Thank you for your further email. My clients response is further detailed below:

From: Simon Davis [redacted]
Sent: 01 October 2019 15:55
To: Pierre Langlois <[redacted]>
Subject: FW: AW/237/19/PL Former Ship Inn

To: Simon Davis <[REDACTED]>
Subject: RE: AW/237/19/PL Former Ship Inn

Title
Site Location Plan with Vehicle Tracking : Articulated Vehicle

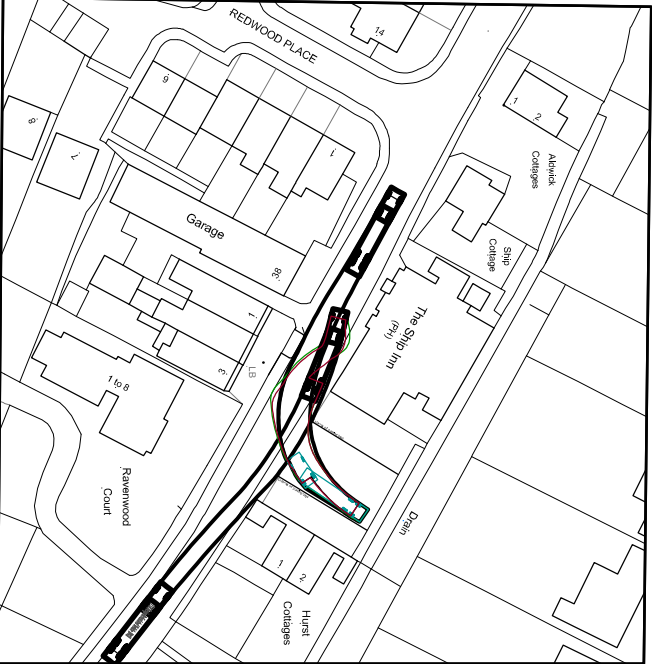
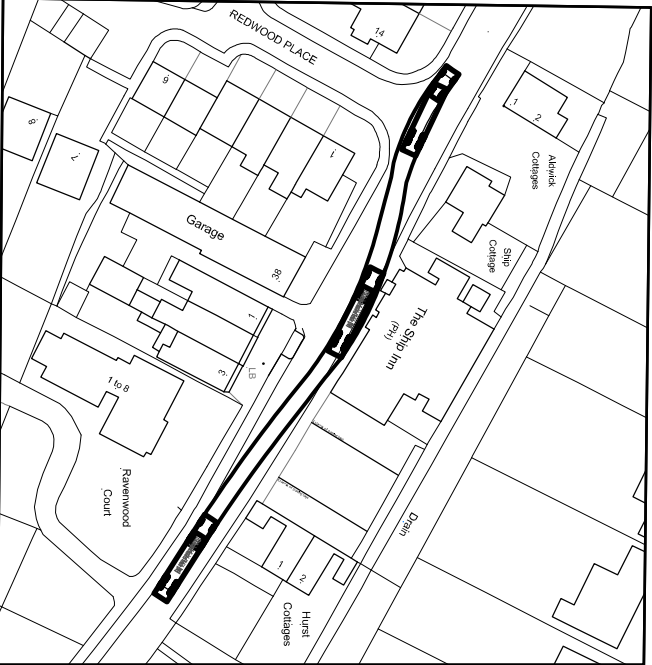
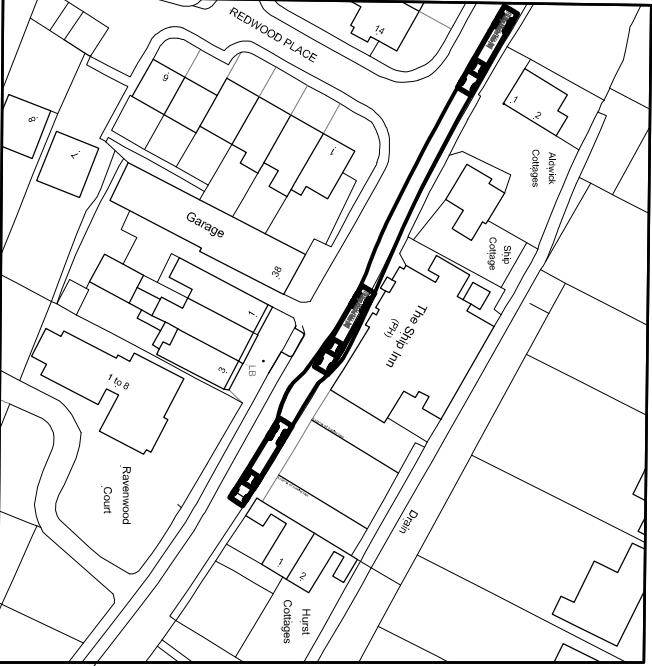
4) Option 1 is preferable as loading and unloading can be undertaken within the site.

5) Although it is not the preferred option, option 2 seems achievable however we need to understand if the highway will be able to operate as a result of the vehicles position. As such please can you include a swept path of a car using the highway at the same time the loading area is in use.

This is our clients preferred method also.

This drawing is attached.

Site Location Plan with Vehicle Tracking : Rigid Vehicle

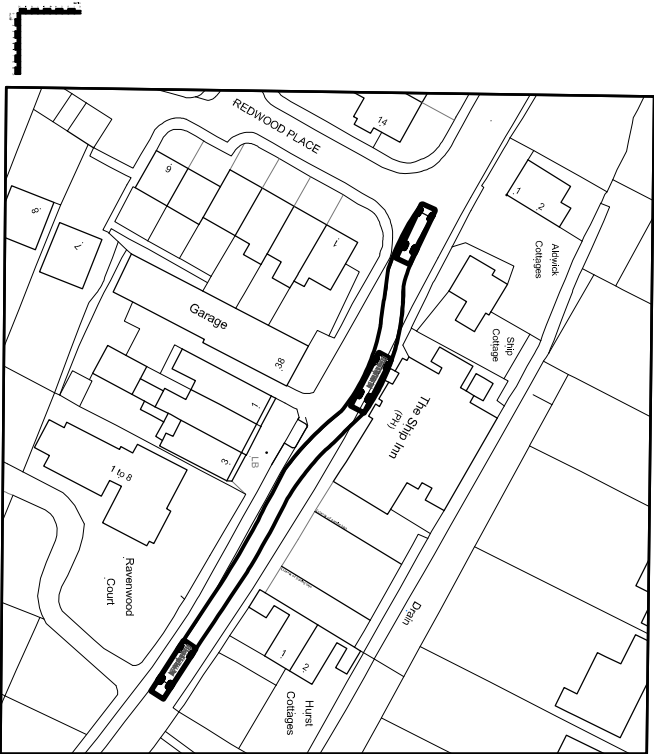
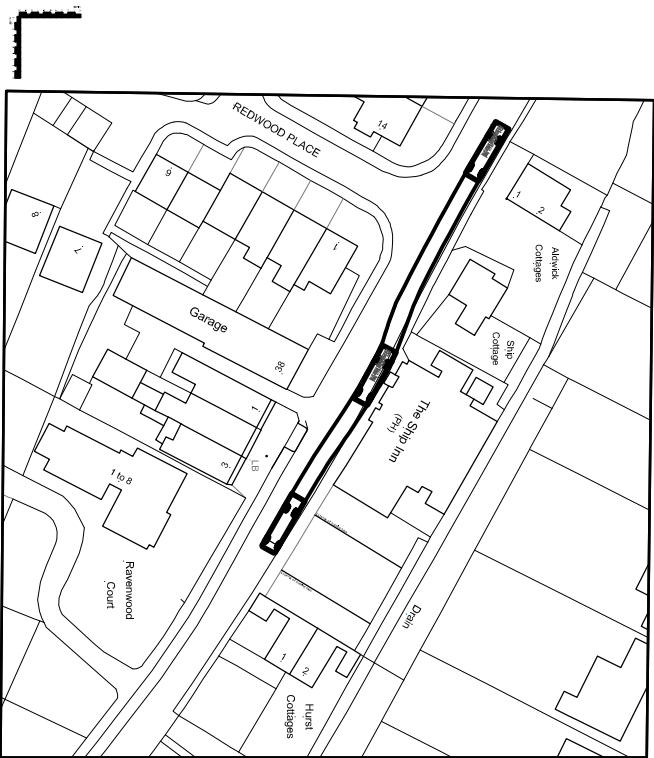
6) Although the swept path diagrams take into consideration the build out, there are also improvements to the northern section of highway. It is noted that the location of the HGV would stop the informal crossing being used. Is there room for the delivery vehicle to keep clear of this at all?

Correct, we are aware of the Northern Section of the highway having a small pavement with dropped kerb, tactile paving, etc. You will see that the attached drawing shows that both vehicle types can stop in a position that does not affect the crossing, albeit that visibility is interfered with, during the period when the vehicle is stopped/unloading. This is why Option 1 is our clients preference. I will also add that there is the possibility of the vehicle parking closer to the building, however this would require the removal of the porch and ground floor bay windows. This is however subject to a separate Planning Permission, if this option was pursued. It would likely result in a kerbside delivery from the highway, but this would not interfere with the crossing point.
